6 February 2018

RMS Reference: SYD16/00625/08

DP&E Reference: SSD7684

**AMENDED CONCEPT PROPOSAL SSD7684 - STAGED REDEVELOPMENT OF COCKLE BAY WHARF - 241 – 249 WHEAT ROAD, COCKLE BAY DARLING HARBOUR**

Central Piers Scheme

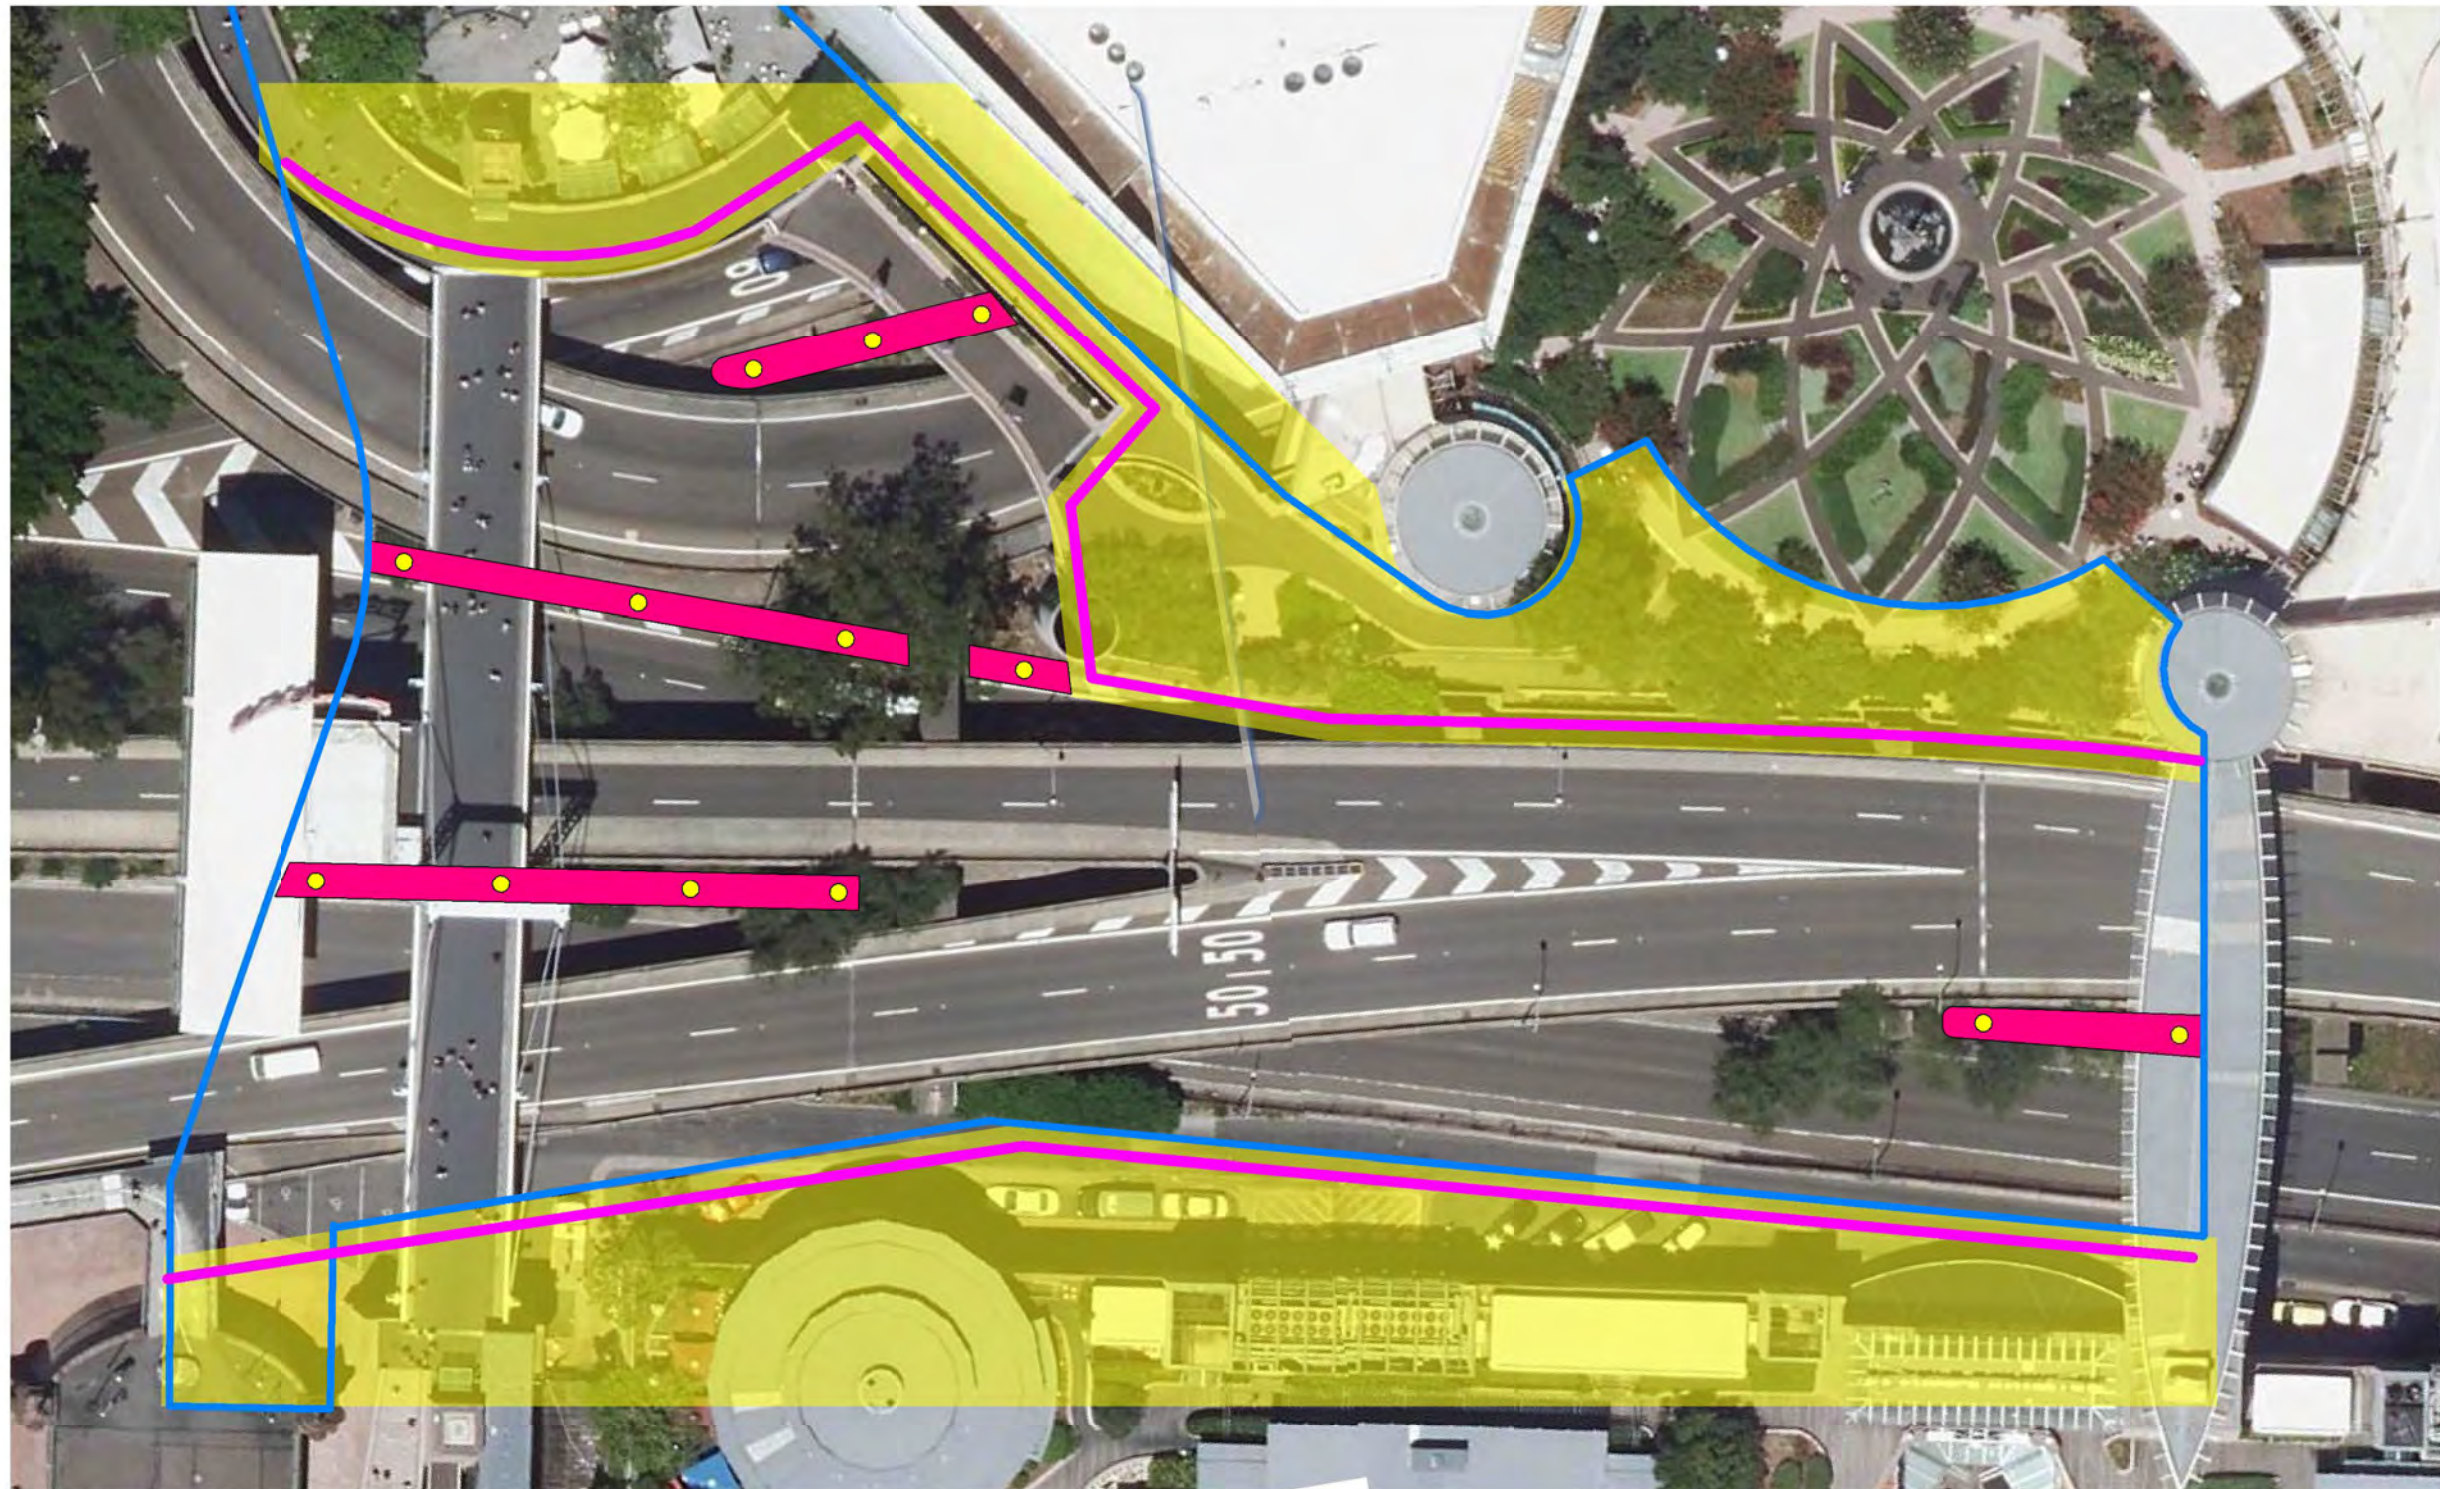
Roads and Maritime previously requested the proponent to identify where the piers for the Podium are proposed to be located in relation to the Western Distributor, including a "no piers" in addition to the proposed "piers" option. To ensure that the Project will not preclude future infrastructure upgrades in the subject corridor, Roads and Maritime requires that the existing road corridor width (between existing barriers and kerbs) beneath the Project is maintained. In this regard:

1. No piers are to be located within the road reserve of the Western Distributor, Wheat Road or Harbour Street.
2. Proposed structures within Zone B, Zone G and Zone H would not be supported.
3. Vehicle roll allowance clearances must be provided when positioning piers.
4. All existing signage impacted by the proposed works would need to be maintained/reinstated.
5. Minimum headroom clearances and fixity of electronic signage (and other ITS equipment) must be provided to new overhead structures.

Future RMS Projects and Structural Zones

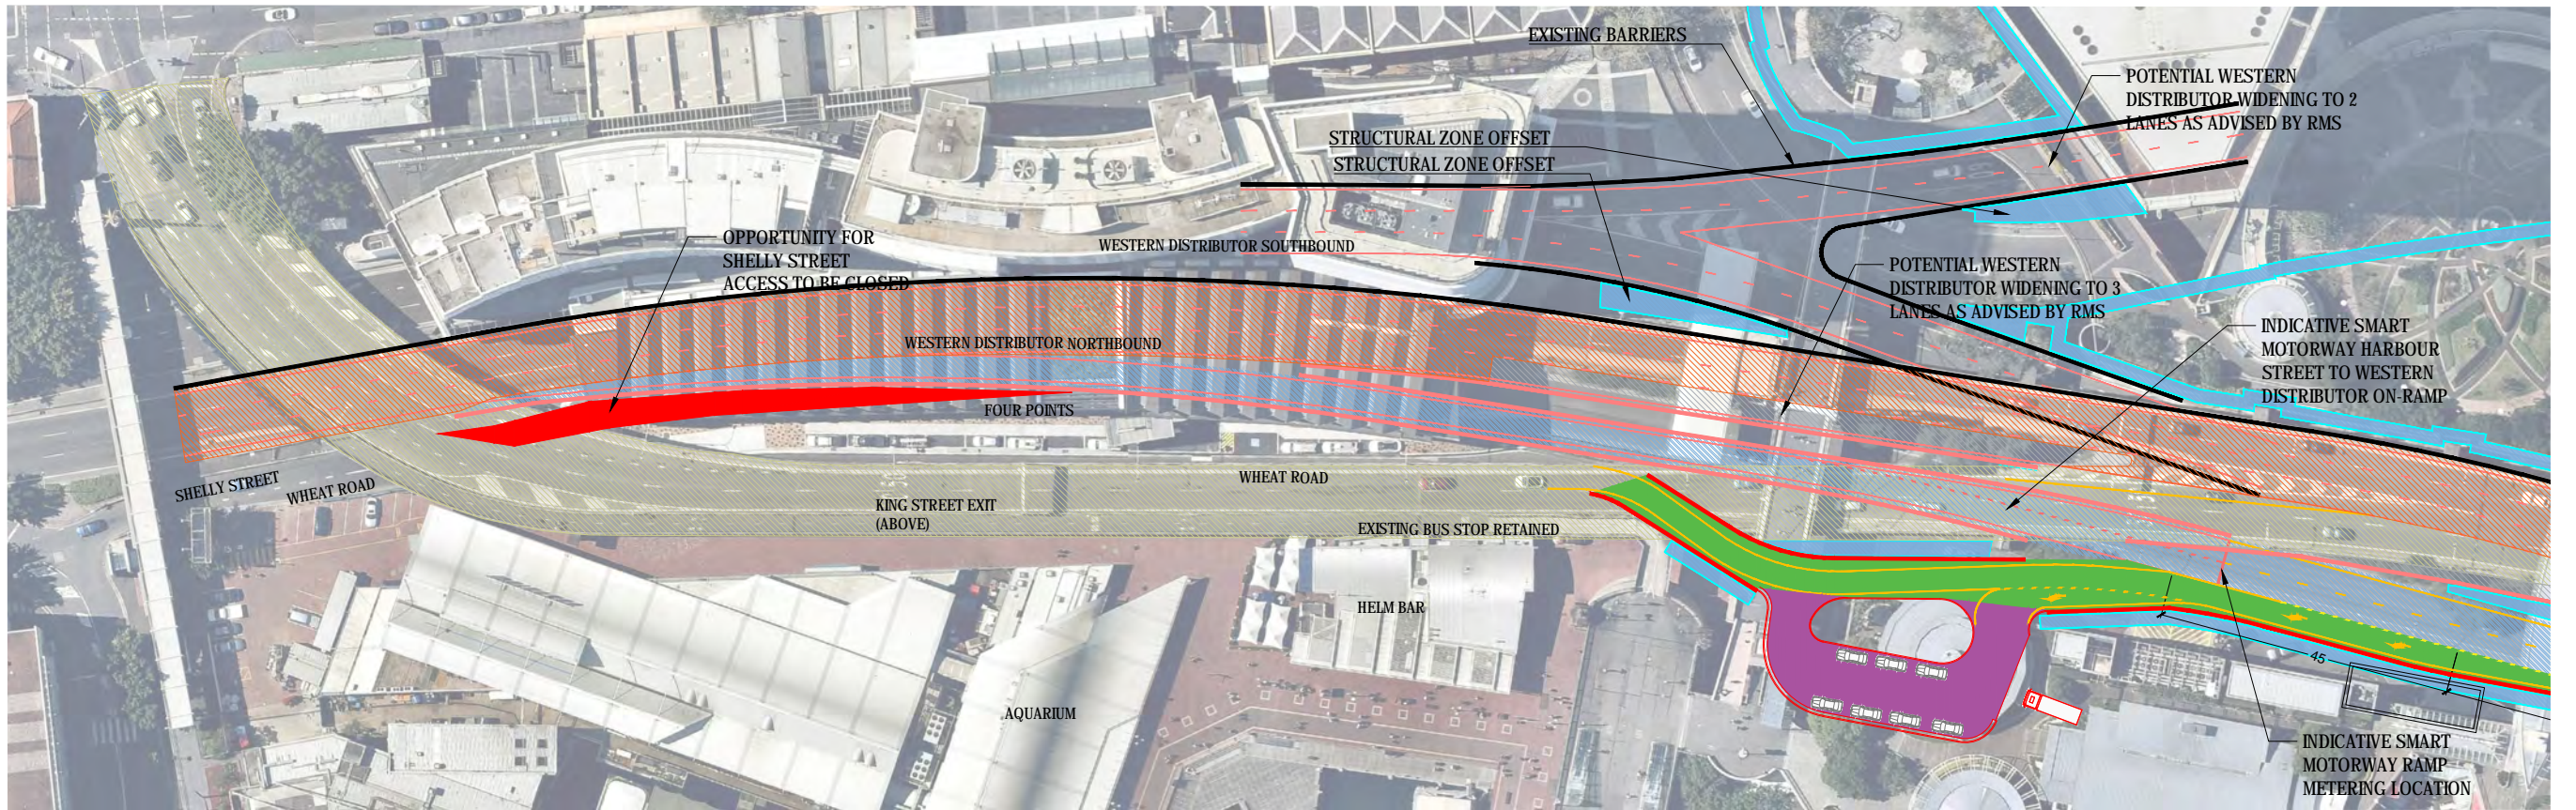
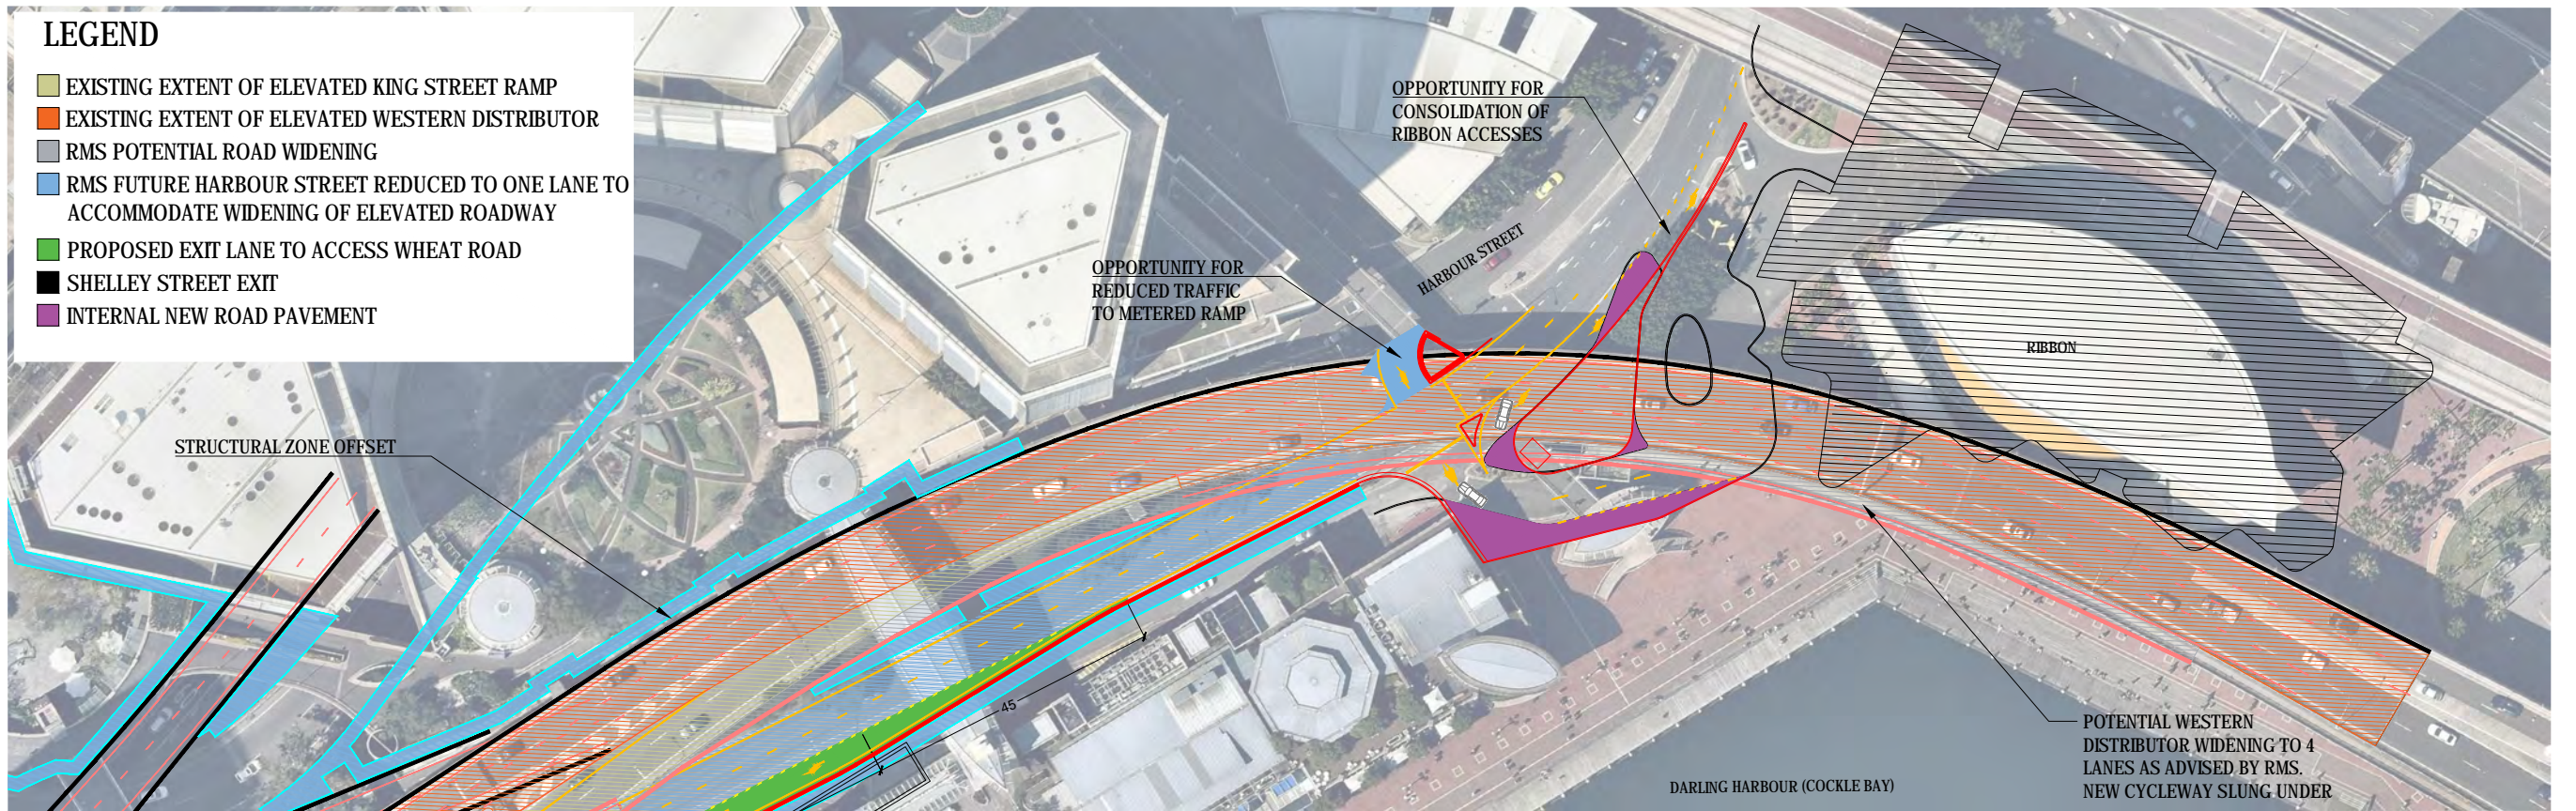
Note: The abovementioned zones are as defined in 'CBW Land Bridge and Options Strategy – 170619'.

**COCKLE BAY PARK
INTENT OF CLEARANCE TO ELEVATED WESTERN DISTRIBUTOR
STRUCTURE**

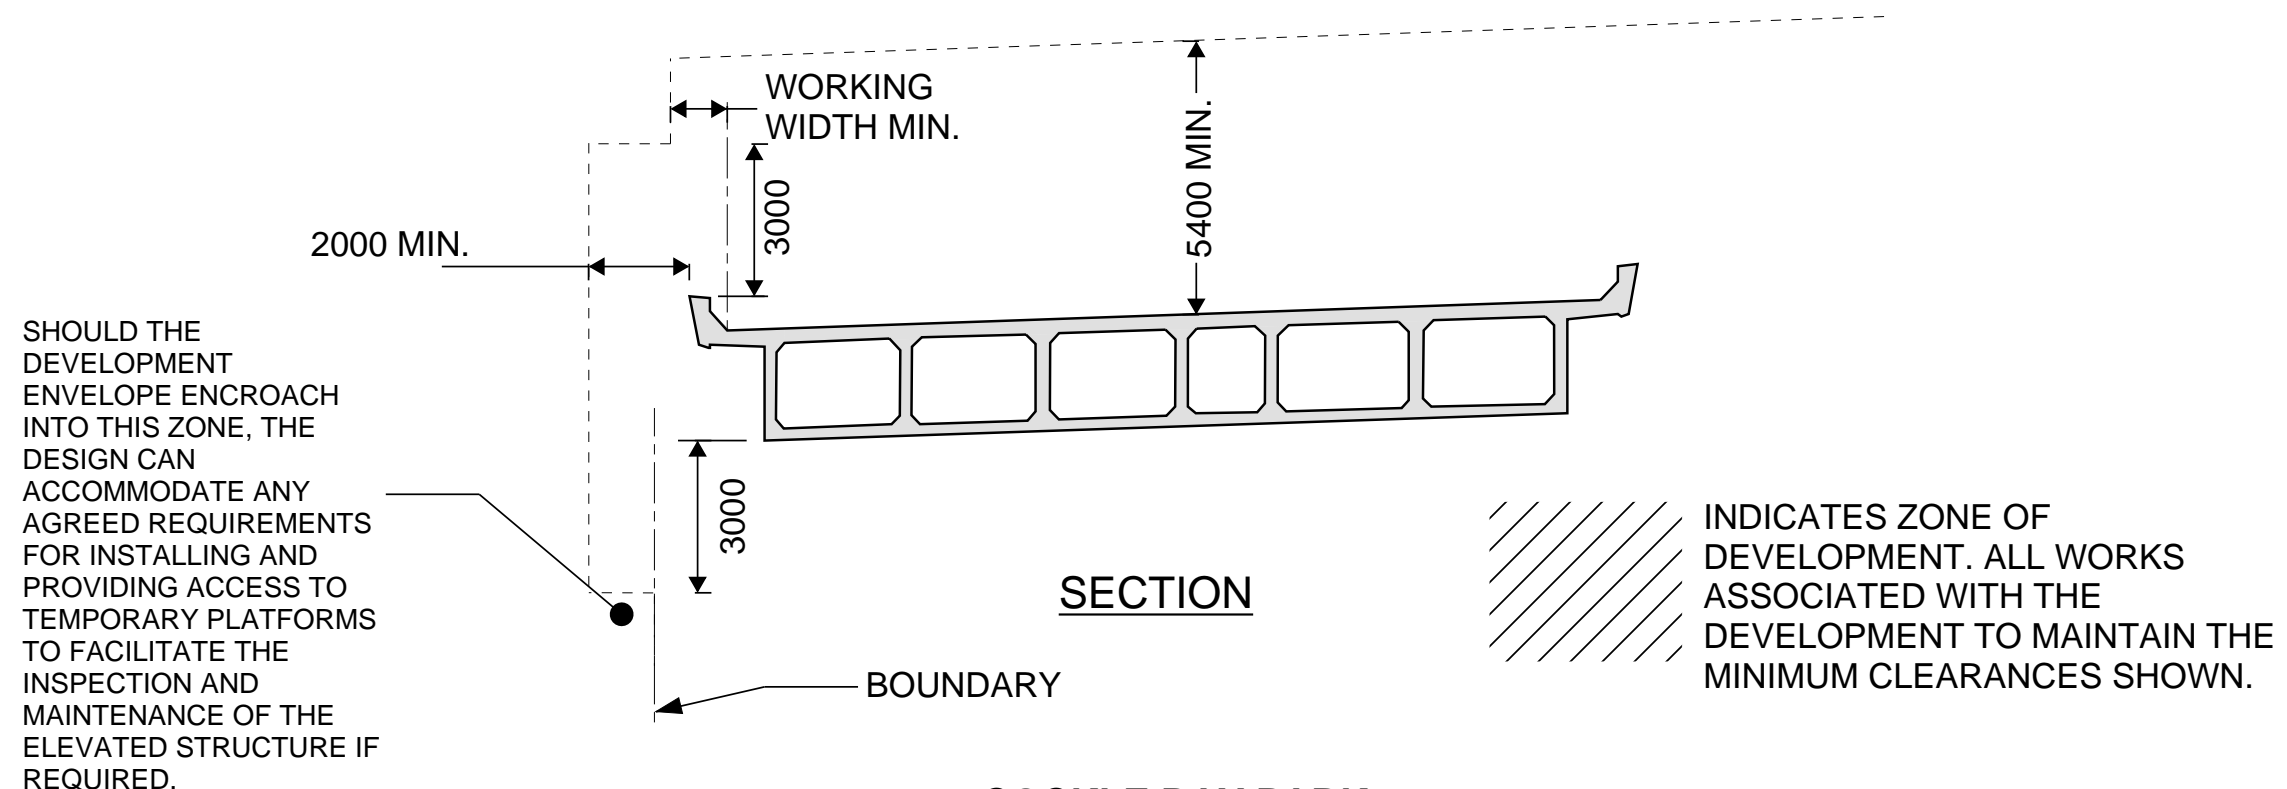
- 12. Minimum Clearance** – the proponent will need to demonstrate that the land bridge and other works built over and in the vicinity of the WD maintain clearance as per RMS requirements.

- Proposed clearance from the Podium to each part of the adjacent Roads and Maritime structure and road, including (but limited to) the deck, column, pile cap and other structures.
